<b>TO:</b>	Helen Donaldson, Sr. Planner	<b>DATE:</b>	10/10/2018
<b>FROM:</b>	Michael Guethle, PE; Ryan Wingard, PE	<b>PROJECT NO.:</b>	13982C
<b>SUBJECT:</b>	Gilman St. - 22; MMC Parking Building (PL-000331-2018)

Wright-Pierce has reviewed the Level III Site Plan Application information provided for the Congress Street Patient Care Building proposed at 22 Gilman Street. The project will include redeveloping an existing parking garage into 64 modern patient rooms and 19 procedure rooms.

Drawing file: Original Submittal / 24 Post Development Watershed Plan sht C60-03.pdf

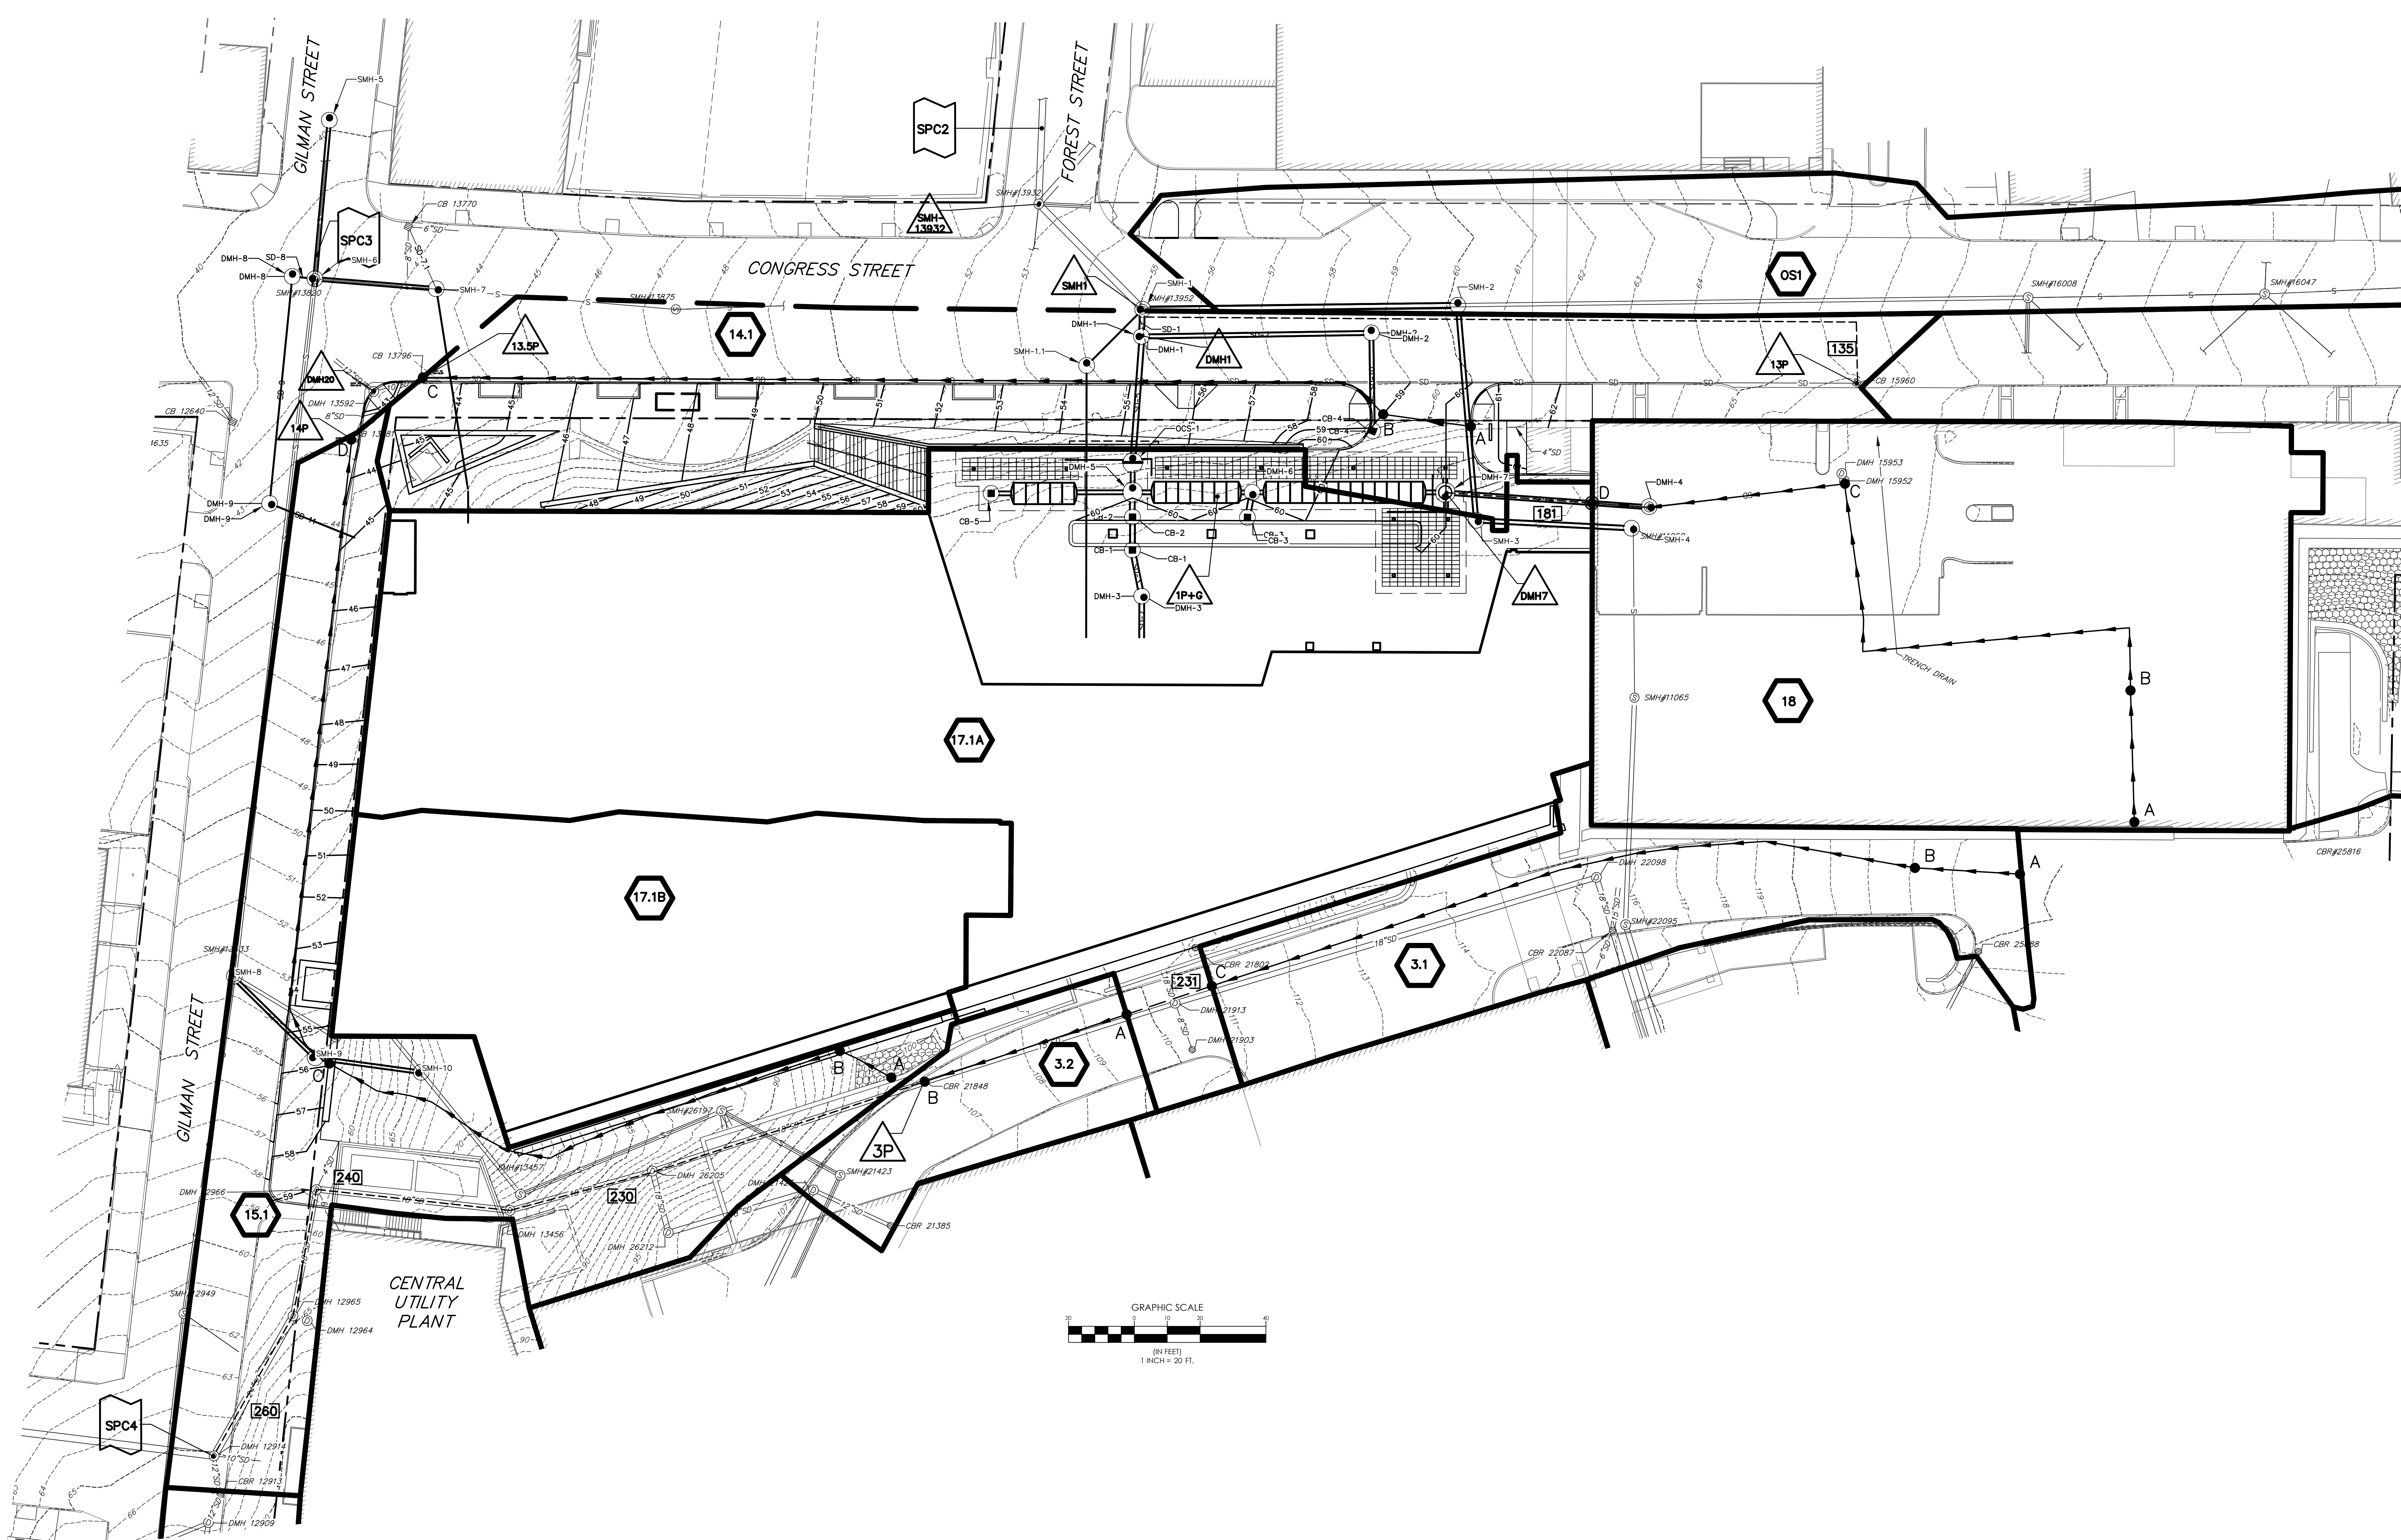
- b. The Pre-Development and Post-Development HydroCAD reports each indicate multiple inflows to Existing SMH-13952. In Table 2, it appears the pre-development flow rate accounts for only flows from Reach 172, and the post-development flow rate accounts for only flows from Reach 135. Please either provide discussion confirming how the pre- and post-development CSO storm events are represented by the model, or provide revised modeling indicating how the other flows to SMH-13952 are represented.

TYPICAL CATCH BASIN
 NOT TO SCALE

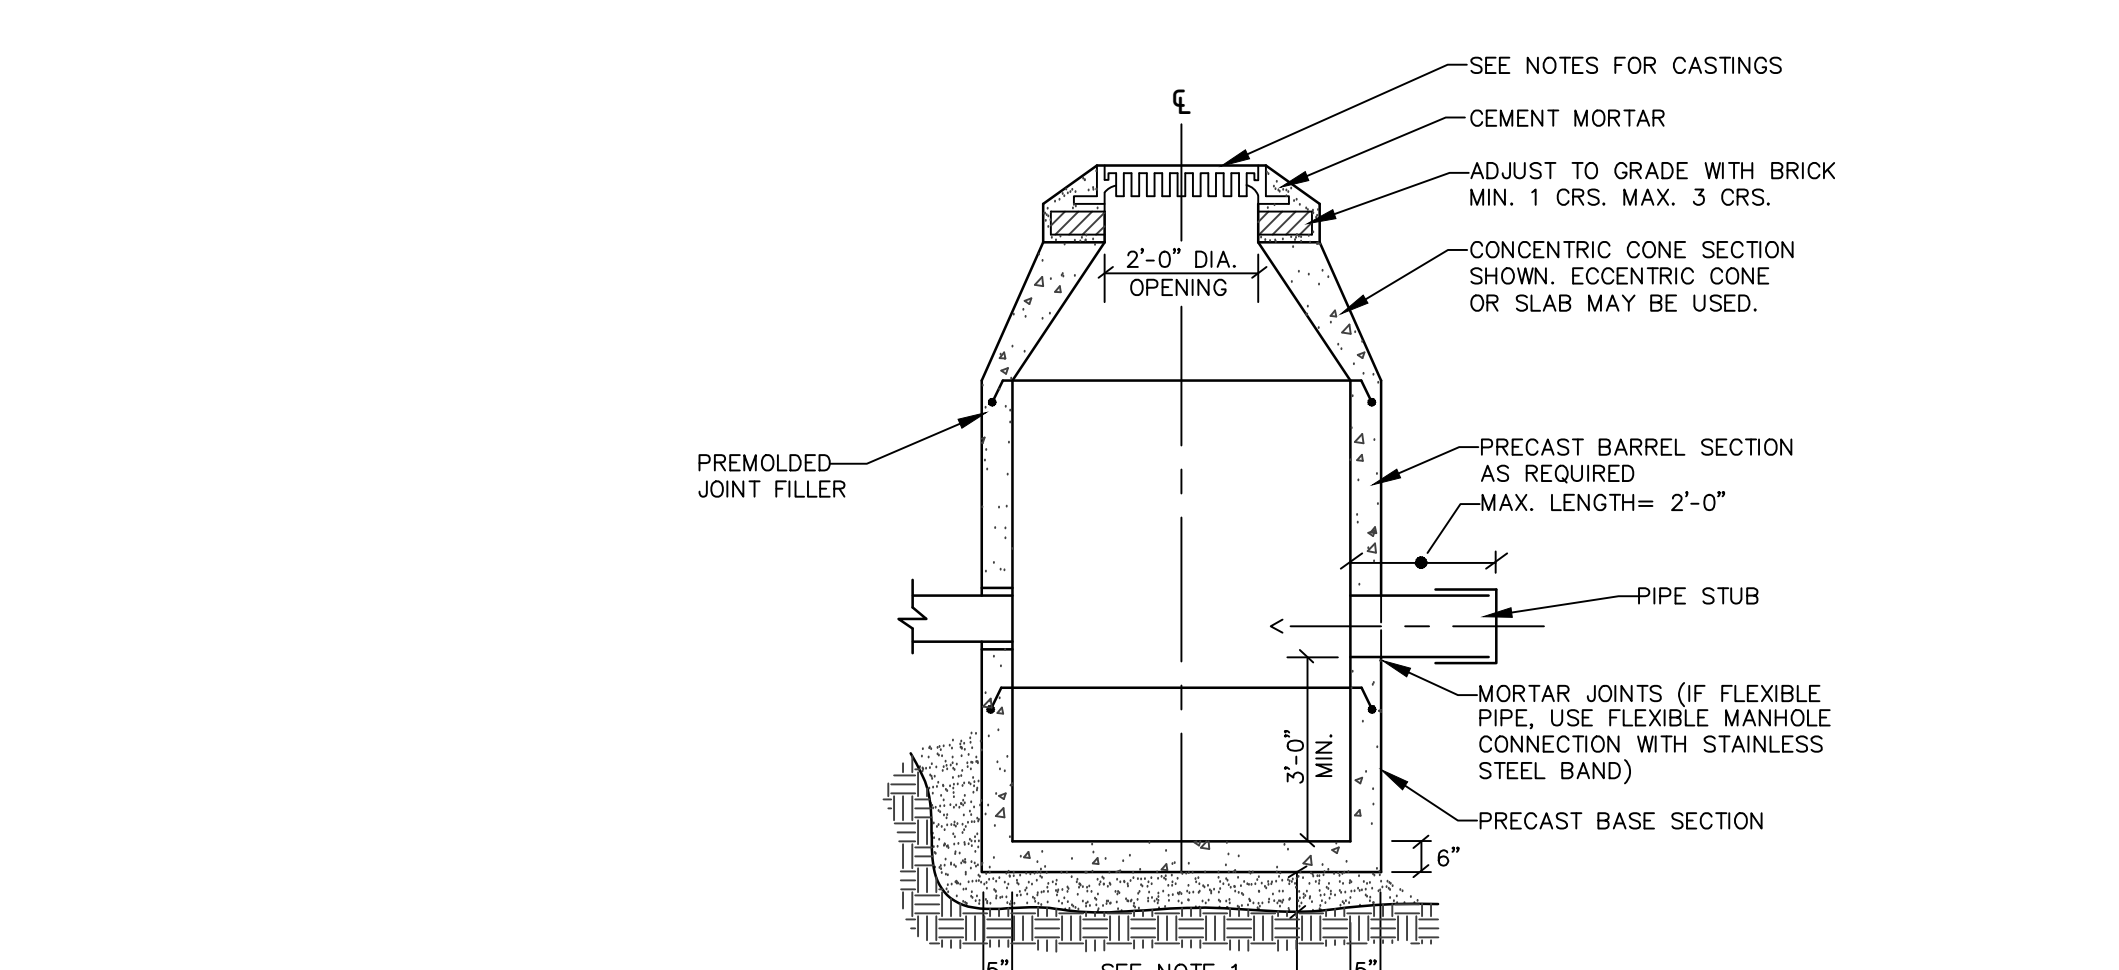
A catch basin detail was included indicating a 2’ sump. Catch basins require 3’ sumps per City Technical Manual. Please revise.

SUBSURFACE SAND FILTER SECTION
 NOT TO SCALE

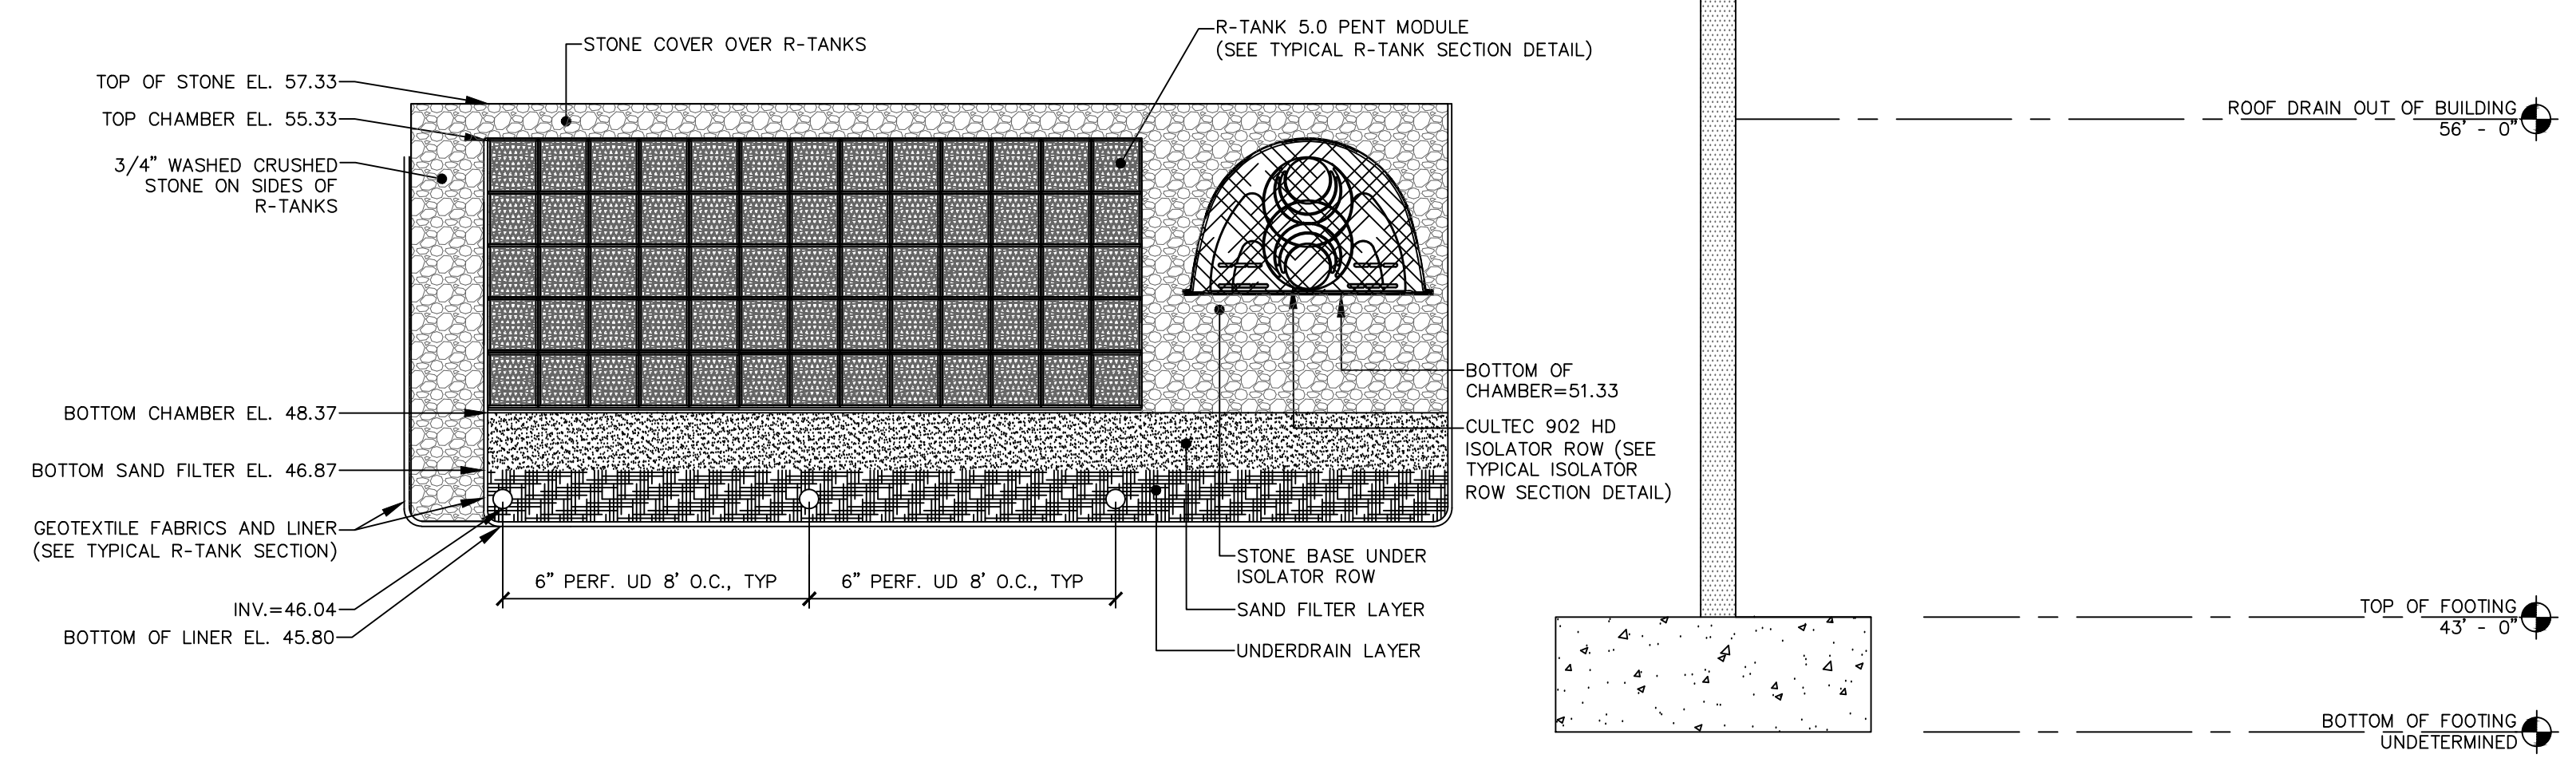
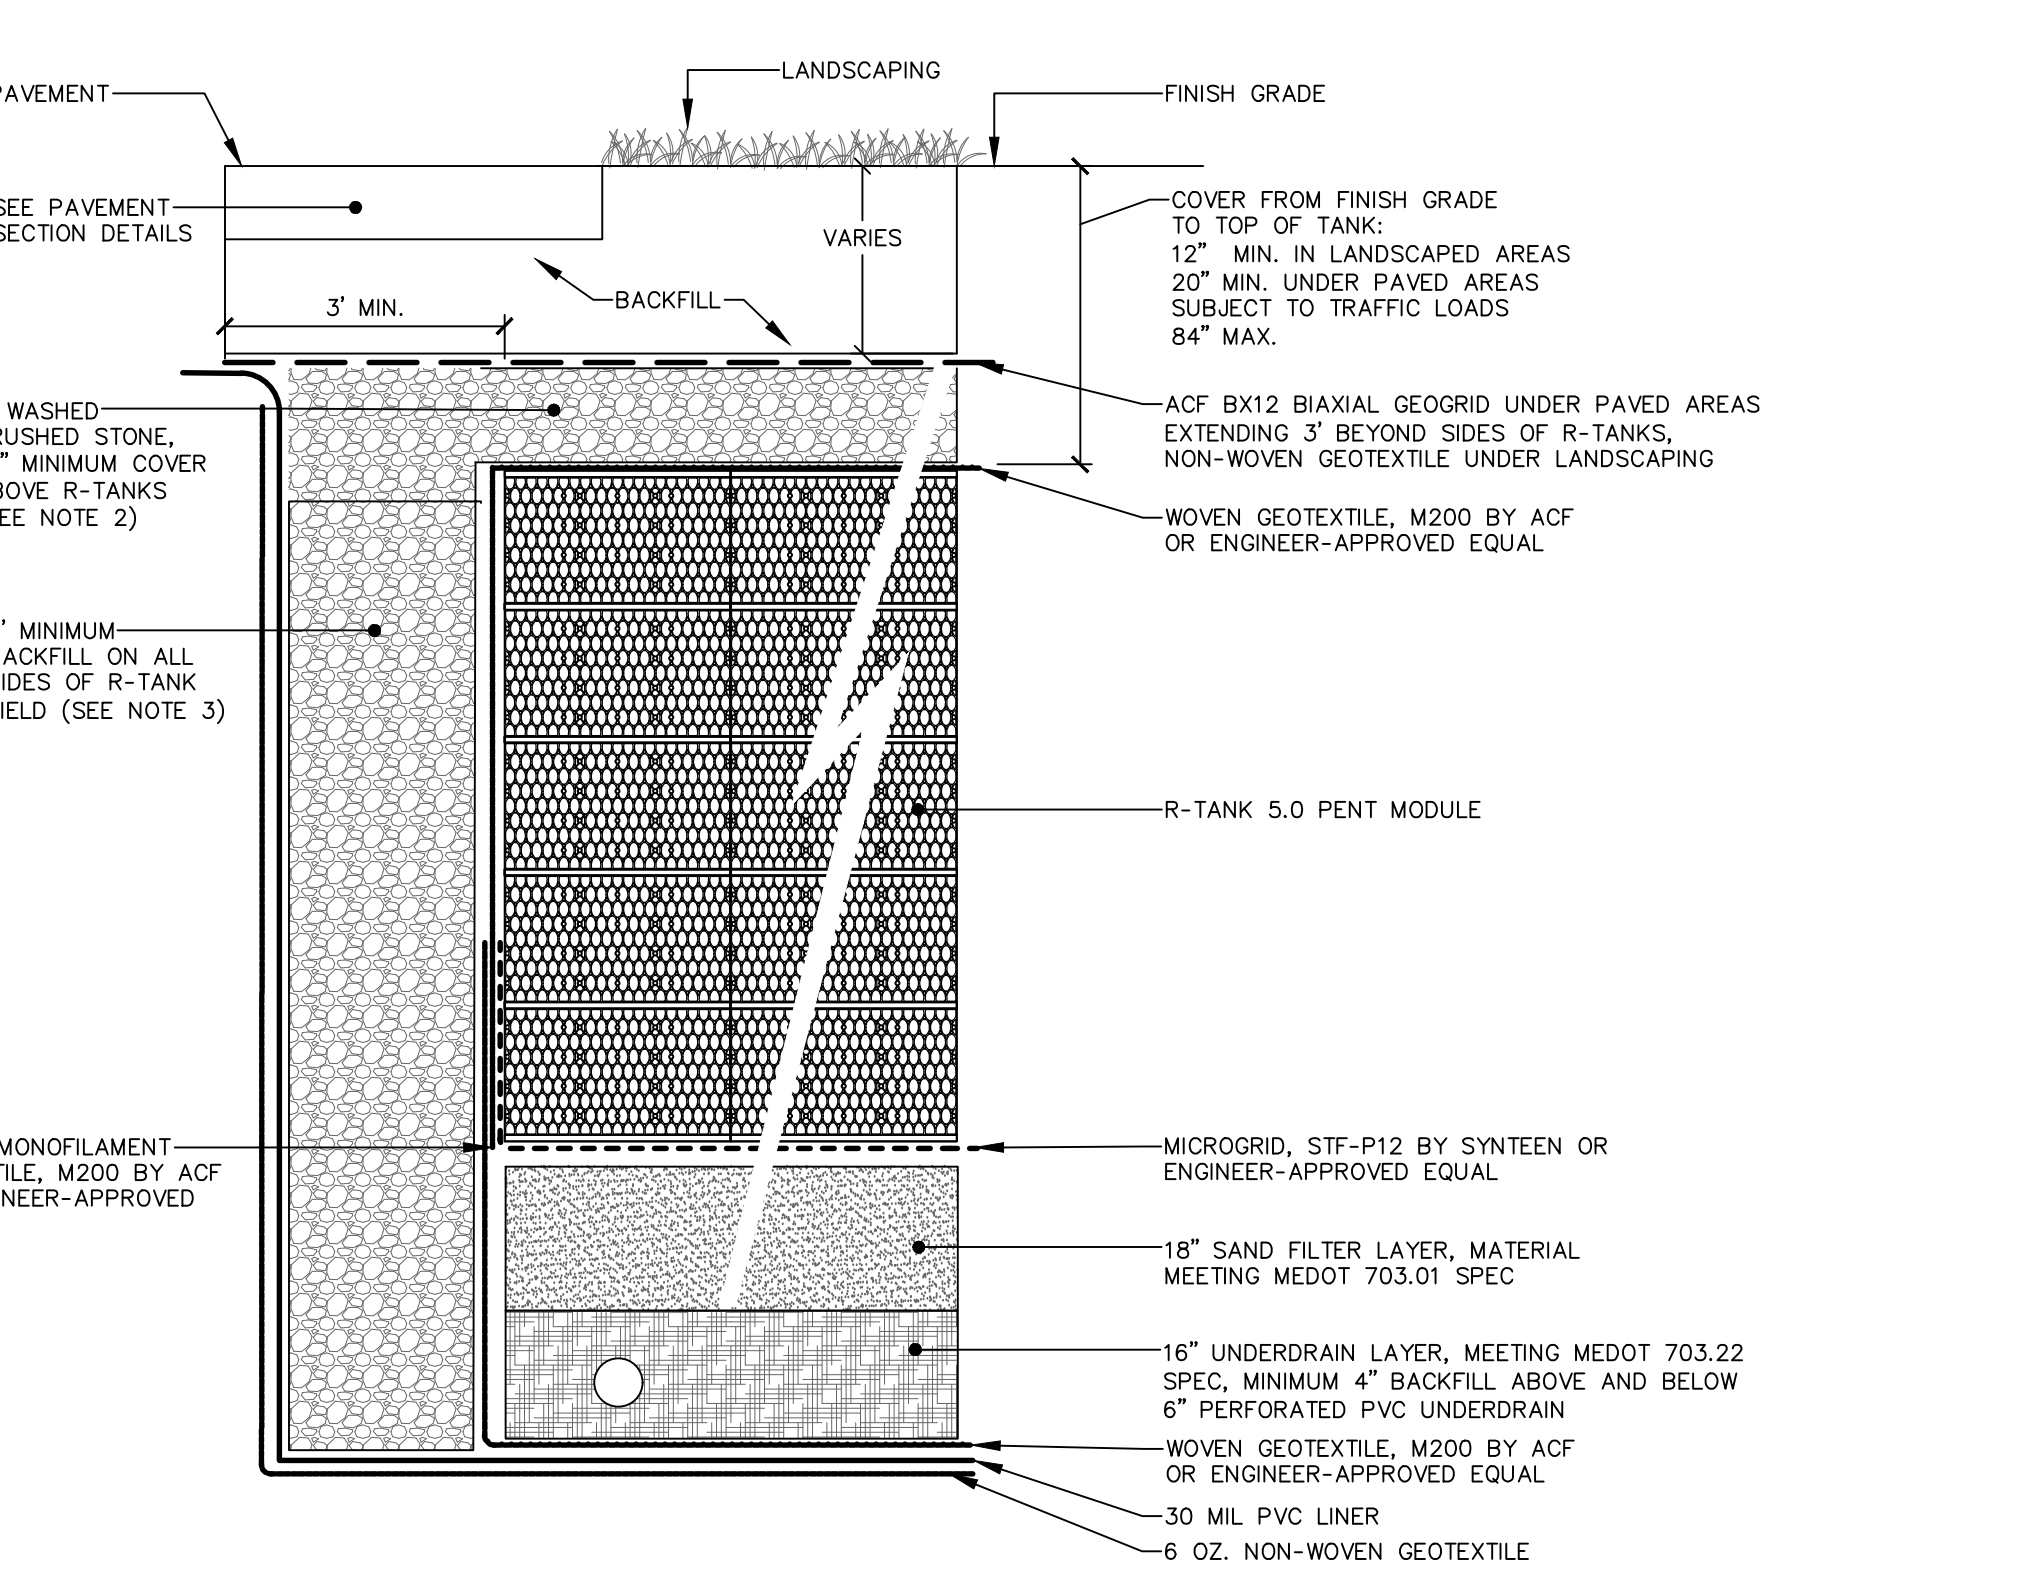
- i. HydroCAD outputs for the 2-year, 10-year, and 25-year, 24-hour storm events have been provided. The model indicates the post-development flow rates for the proposed project do not exceed flow rates for the pre-development condition.
- ii. “Subsurface Sandfilter Section” details match the HydroCAD model. Additional pipe invert, pipe length, and pipe size information on grading

plans and details are needed to confirm that the HydroCAD model matches permitting plans.
